**From:** Contact Centre (CRM) <contact@ribblevalley.gov.uk>  
**Sent:** 17 December 2024 13:27  
**To:** Planning  
**Subject:** Planning Application Comments - 3/2024/0858 FS-Case-671285594

**Planning Application Reference No.:** 3/2024/0858

**Address of Development:** Back Castle Works, Pendle Court, Longridge, Preston PR3 3WY

EXISTING (AS-BUILT) SITE PLAN

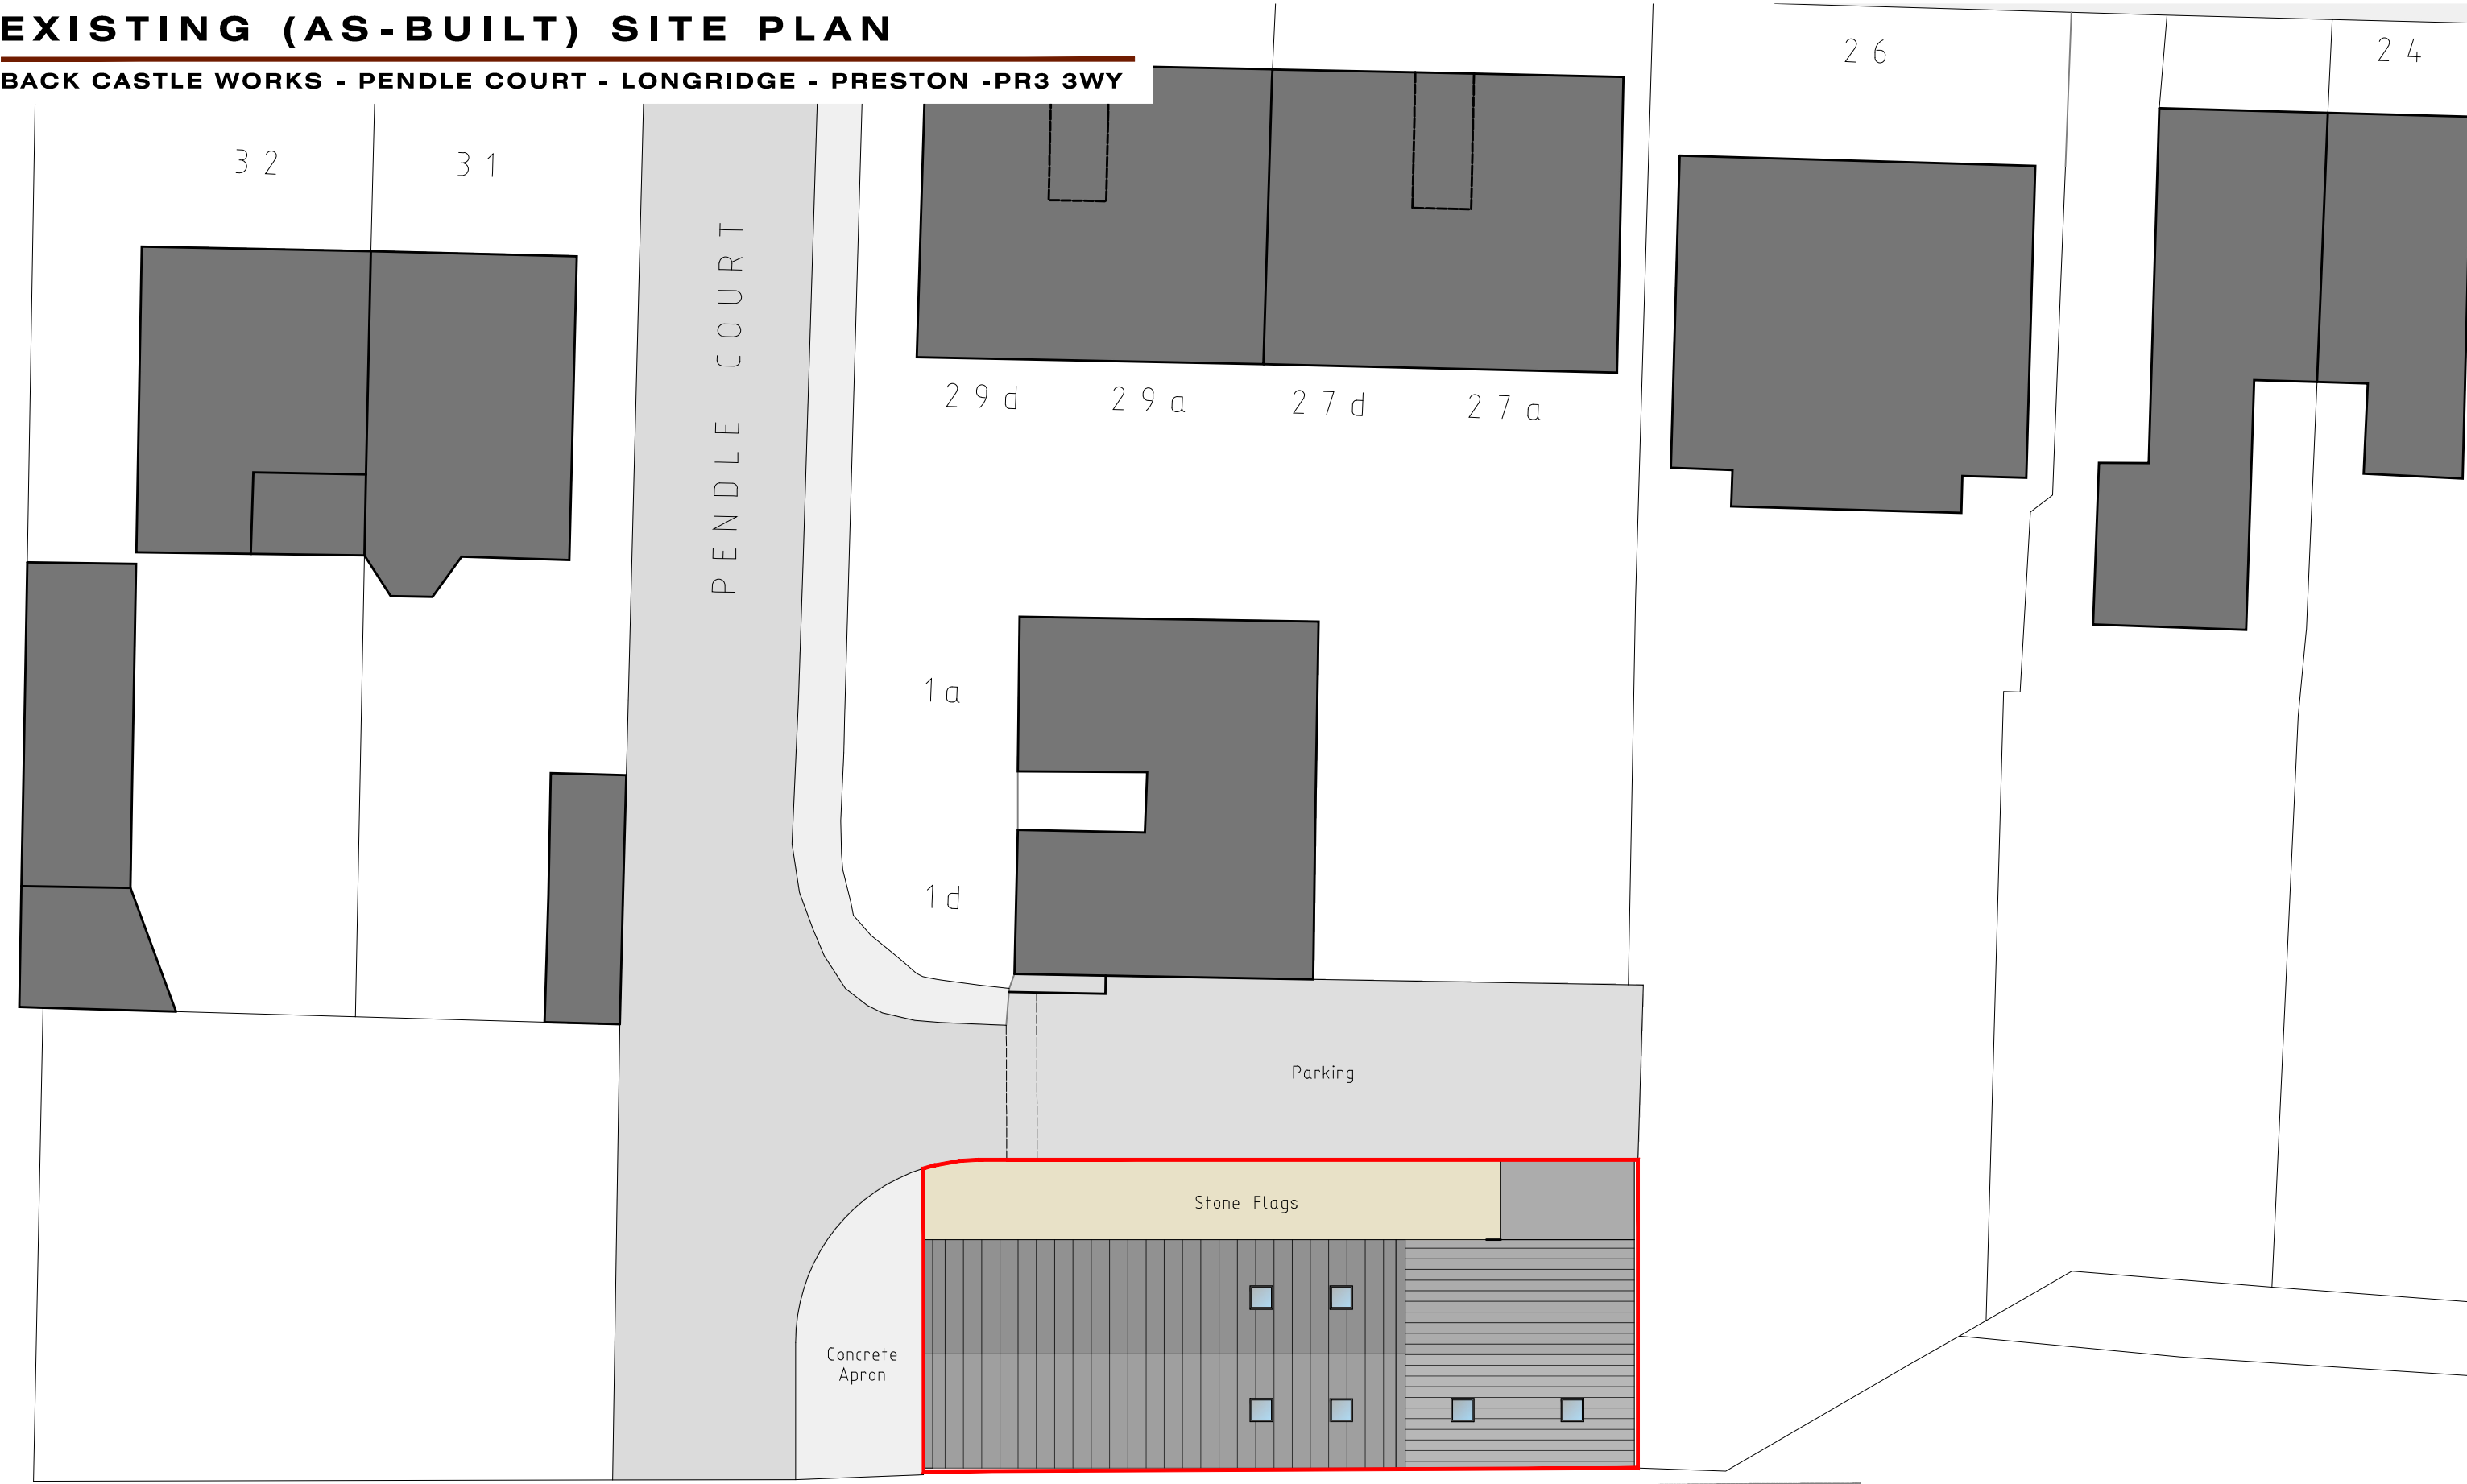
I concur that the indication of 'parking' on the "Existing (As-Built) Site Plan" is indicated in the wrong place and should be labelled over the rectangle of land at the South West corner of the drawing, across the carriageway from the gable end of Back Castle Works. I have a plan of this parking area which is reserved for the owners of the twelve adjacent flats. However, it is rarely used and normally chained off, as owners or people visiting the flats park on the metalled carriageway or on the access where the author of the site plan had indicated 'parking' along their gable.
